# DELEGATED HOUSEHOLDER DECISION

**Item No. Report of the Head of Development Management and Building Control****Address:** 44 WARREN ROAD ICKENHAM**Development:** Erection of conservatory**LBH Ref Nos:** 17392/APP/2024/121**Drawing Nos:** 44WR-RE/10022022/REV-G-1/2  
44WR-RE/10022022/REV-G-2/2**Date Plans received:** 17-01-24 **Date(s) of Amendments(s):****Date Application valid** 17-01-24**1. CONSIDERATIONS****1.1 Site and Locality**

The application seeks planning permission for the erection of a conservatory onto a newly built single storey rear extension approved under REF: 17392/APP/2022/3870.

DRAWING NO.: 44WR-RE/10022022/REV-G-2/2

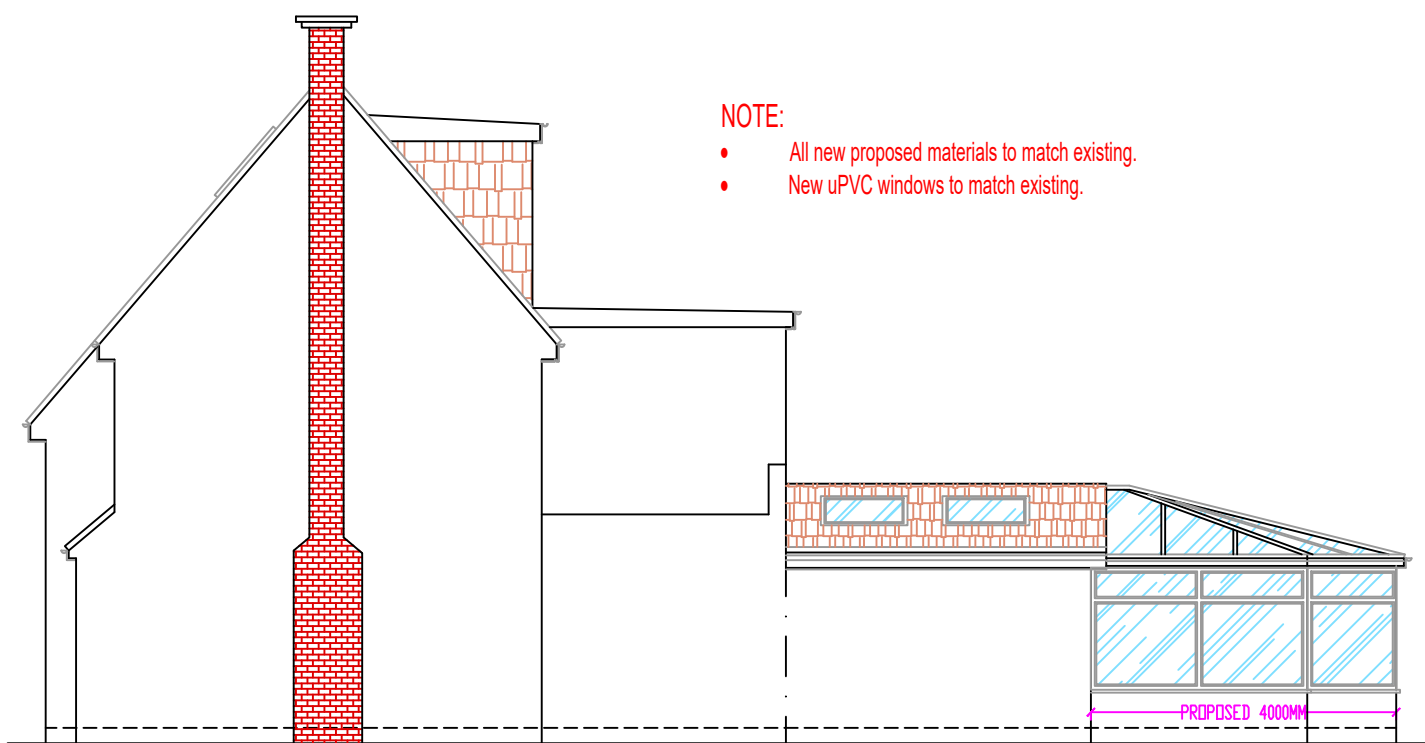
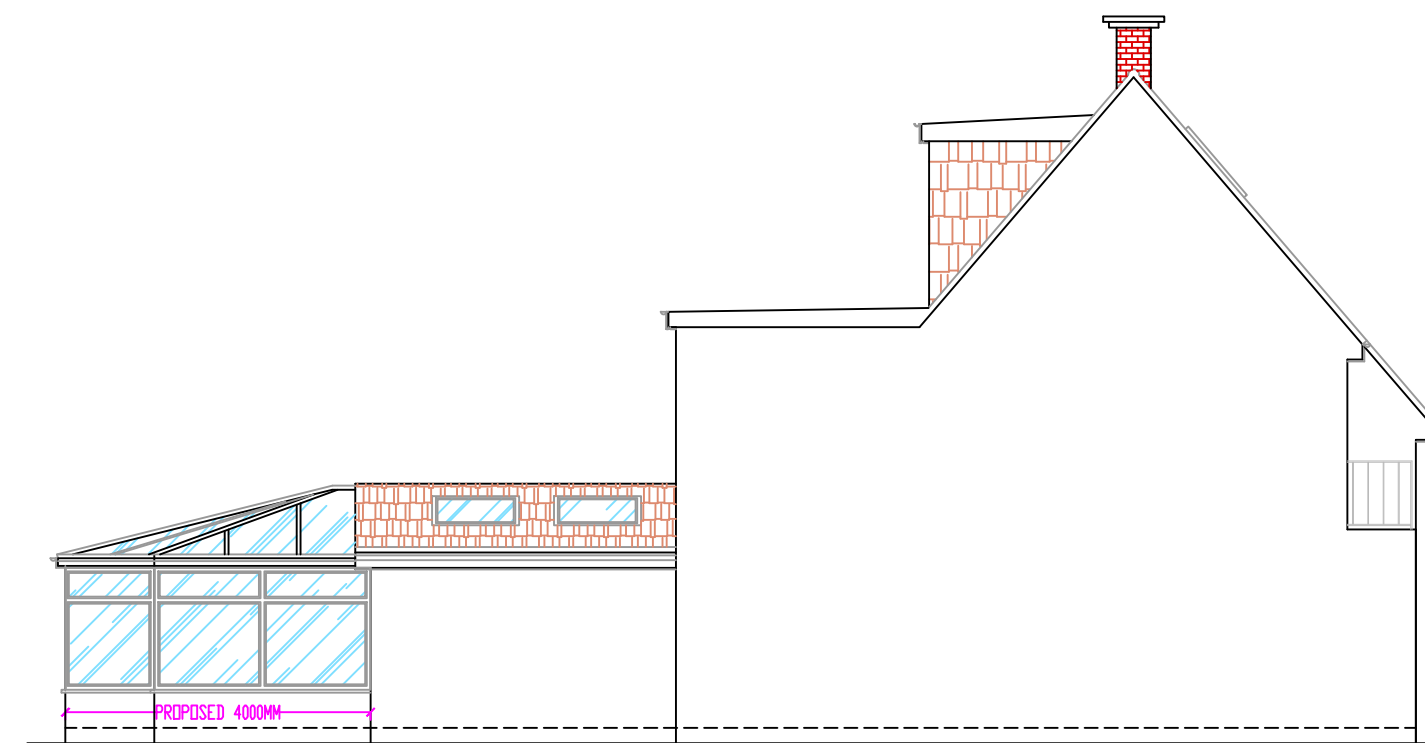
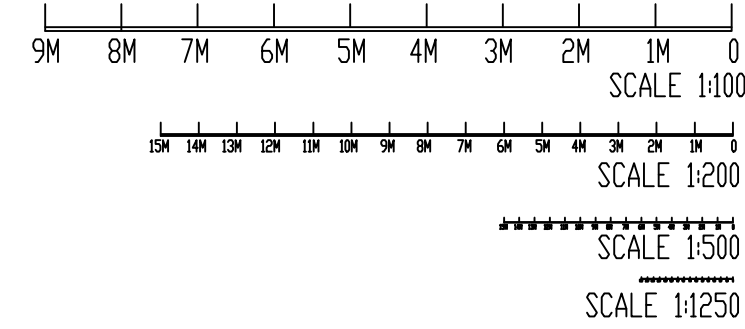
The proposed conservatory extension would measure 4m in depth and a width of 7m, which would centrally extend across the recently built rear extension built under REF: 17392/APP/2022/3870. It would be set in from both sides of the existing extension and would be characterised by its sloping glazed roof measuring a maximum height of 3.1m and 2.1m height to the eaves. A low wall is proposed with glass panels above.

In terms of the cumulative depth of rear extensions at this property, the 4m depth of the conservatory, added to the existing recently built 4m depth of the existing extension would exceed the prescribed measurements set out in policy DMHD1 of the Hillingdon Local Plan Part 2 (2020). Creating a disproportionate and over dominant addition to the dwelling, and therefore is considered harmful to the character and appearance of the original property.

The proposed conservatory extension would be set away from the shared boundaries with No.42 and 46 an although the structure is made from mainly glazing and would be partially obscured by the presence of a boundary fence the conservatory would result in a visual impact upon the views from within the garden of the neighbouring properties when viewed in combination with the depth of the existing rear additions. As such it would result in a reduction in the visual amenities of the neighbouring properties. It should also be noted that whilst the materials proposed would reduce the potential impact, the principle of extending to this depth would be harmful if established.

The proposed single storey rear conservatory extension, by reason of its size, scale, bulk, depth and positioning adjoining the recently constructed 4m extension, would be excessive and disproportionate to the original dwelling and would not appear as a subordinate addition. The proposal would therefore be detrimental to the character and appearance of the original dwelling, contrary to Policy BE1 of the Hillingdon Local Plan: Part One Strategic (2012) and Policies DMDH 1, DMHB 11 and DMHB 12 of the Hillingdon Local Plan: Part Two - Development Management Policies (2020).

The proposed single storey rear extension, by virtue of its size, scale, bulk, depth and proximity, would be detrimental to the amenities of the adjoining occupiers at 42 and 46 Warren Road, by reason of overdominance, overshadowing, visual intrusion, loss of light and loss of outlook. Therefore, the proposal would be contrary to Policies DMHB 11 and DMHD 1 of the Hillingdon Local Plan: Part Two - Development Management Policies (2020).
